From: Joanne Lewis <Joanne.Lewis@arun.gov.uk>
Sent: 01 October 2021 14:29
To: Planning.Responses <Planning.Responses@arun.gov.uk>
Subject: RE: Planning Consultation on: BN/126/21/DOC

Application No: BN/126/21/DOC

Site Address: Tile Barn Farm 32 Hill Lane Barnham PO22 0BL

Description of Works: Approval of details reserved by condition imposed under ref W/4001228 (BN/24/20/PL) relating to Condition Nos 3 - materials and finishes, 5 - noise, 6 - dustbin enclosure, 7 - renewable energy, 10 - covered & secure cycle parking, 11 - electric vehicle charging, 12 - surface water drainage and 13 - foul drainage.

GROUND FLOOR PLAN
Scale 1:50

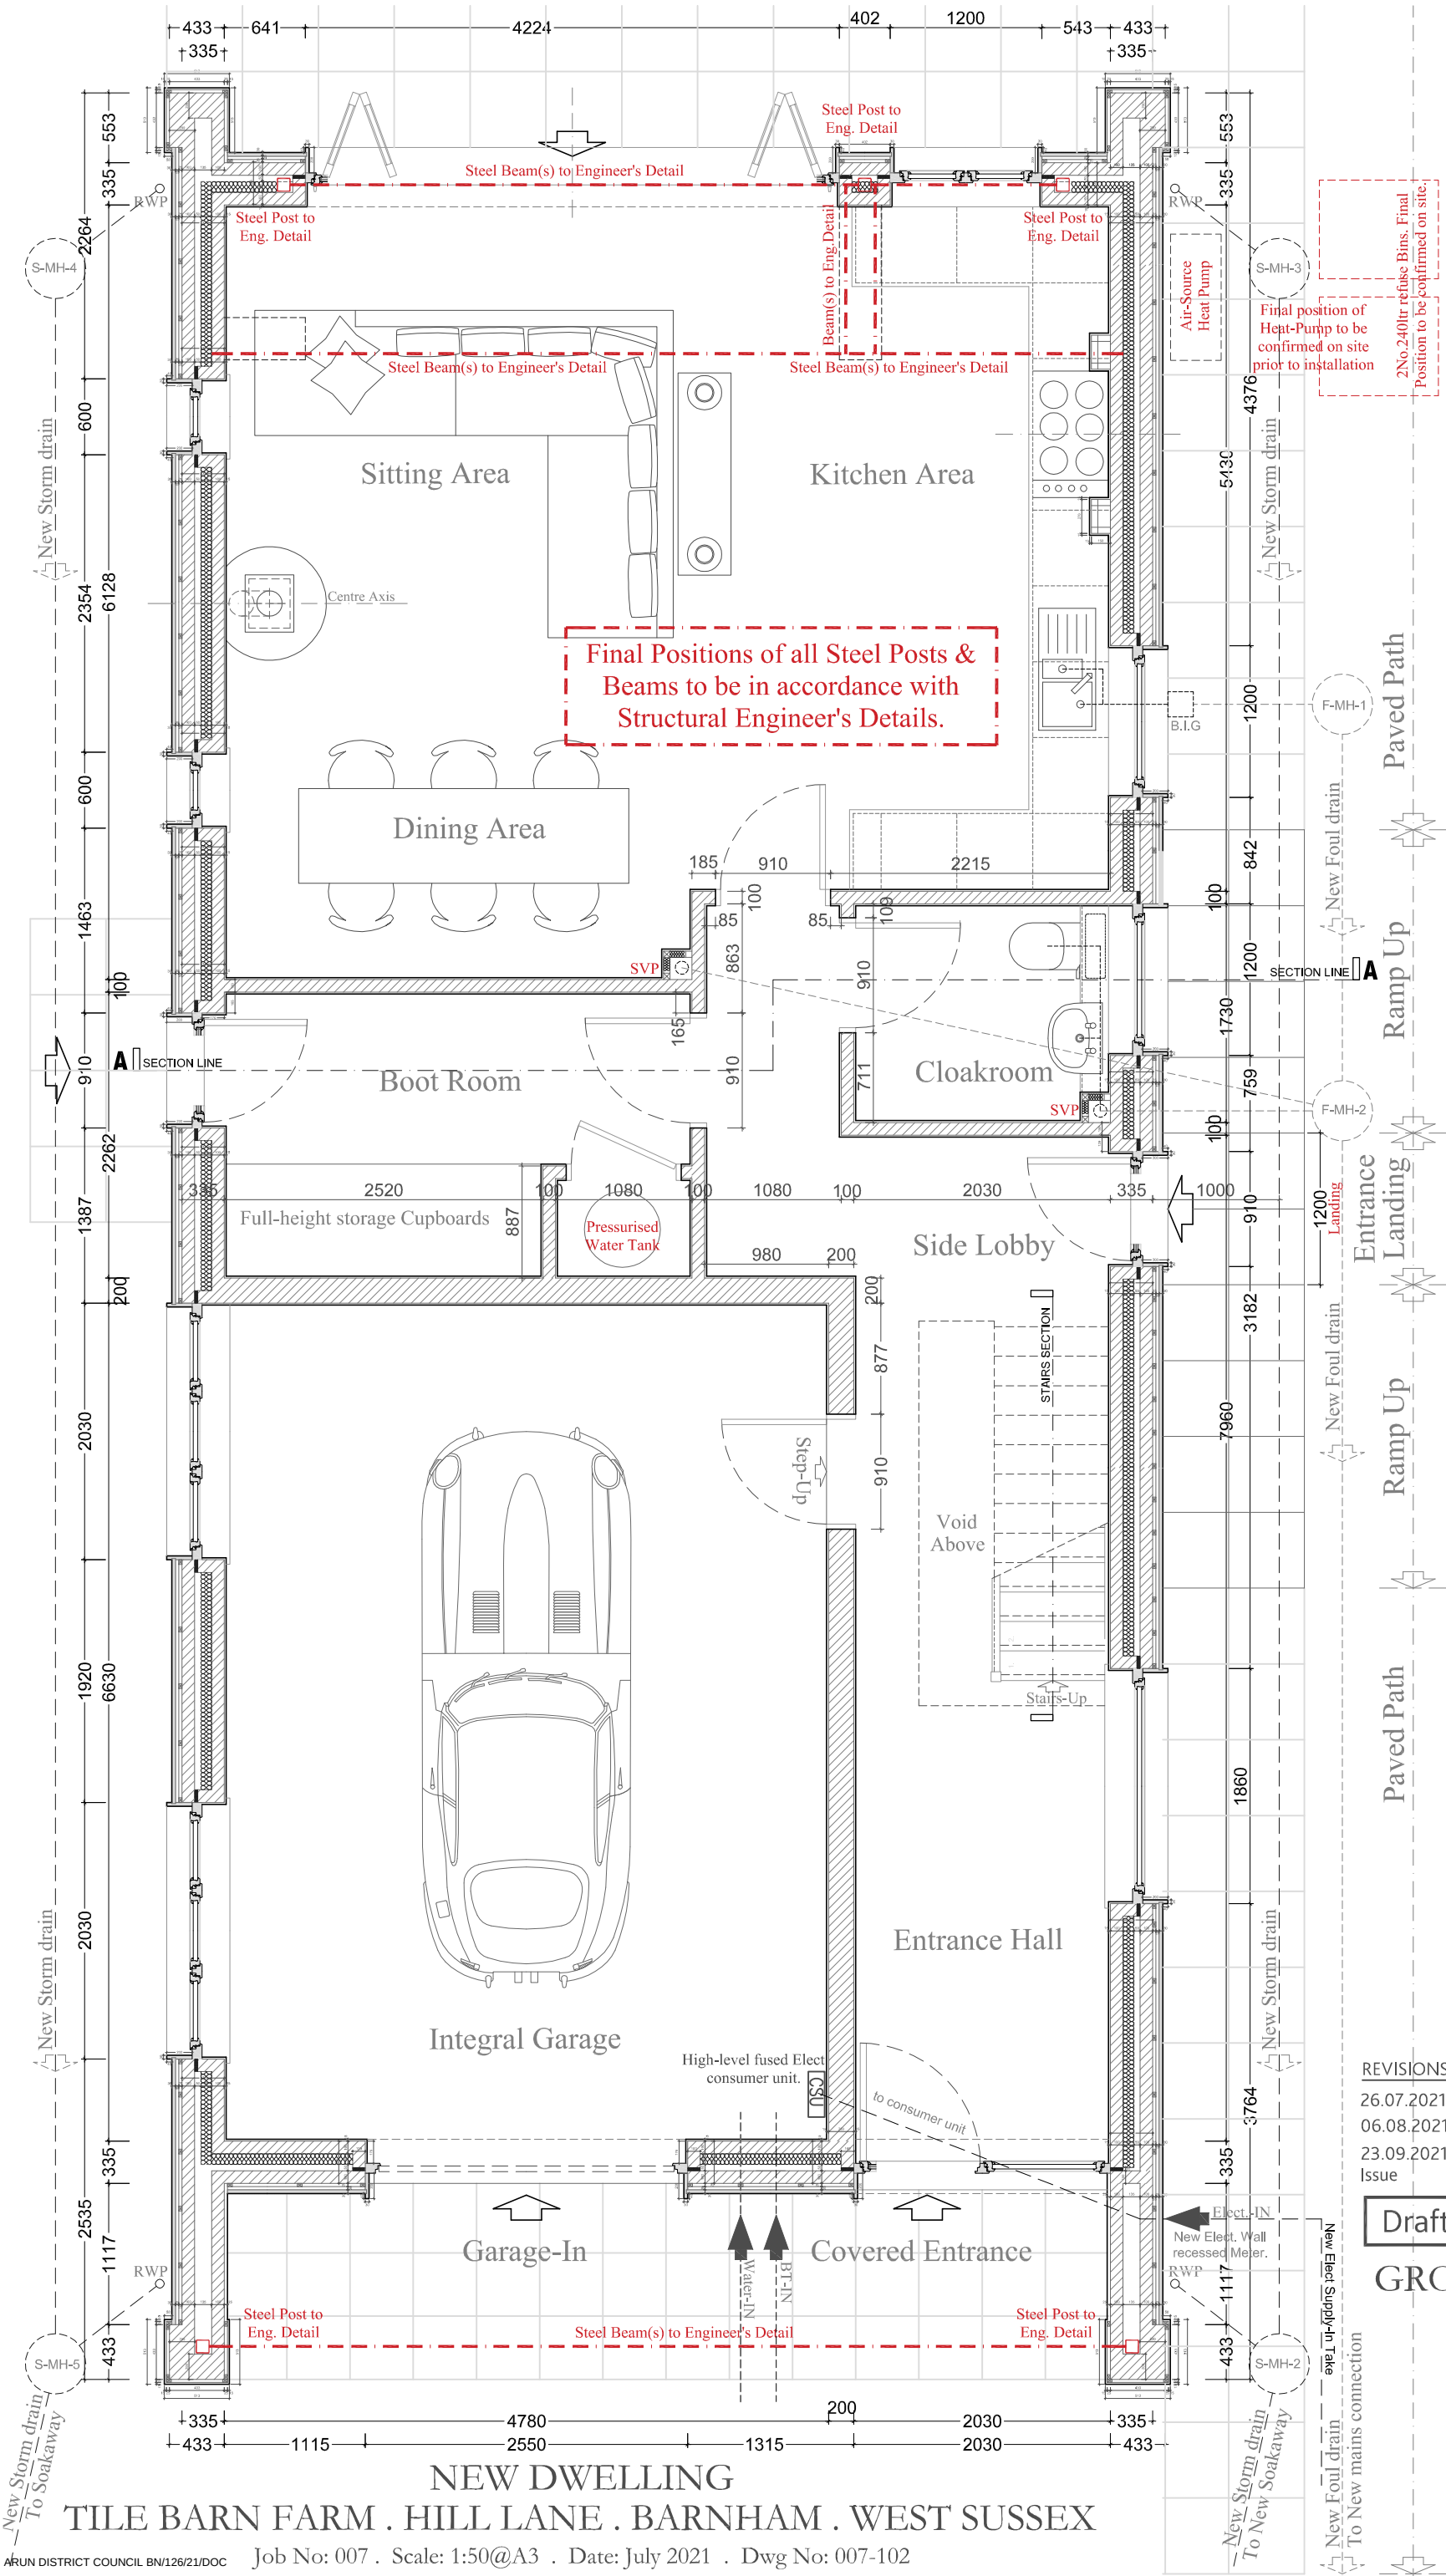
The location of the charger is acceptable but detail should be provided on the type of charger to be installed before discharge of this condition can be recommended. Chargers should be Mode 3, 7kw fast chargers as a minimum.
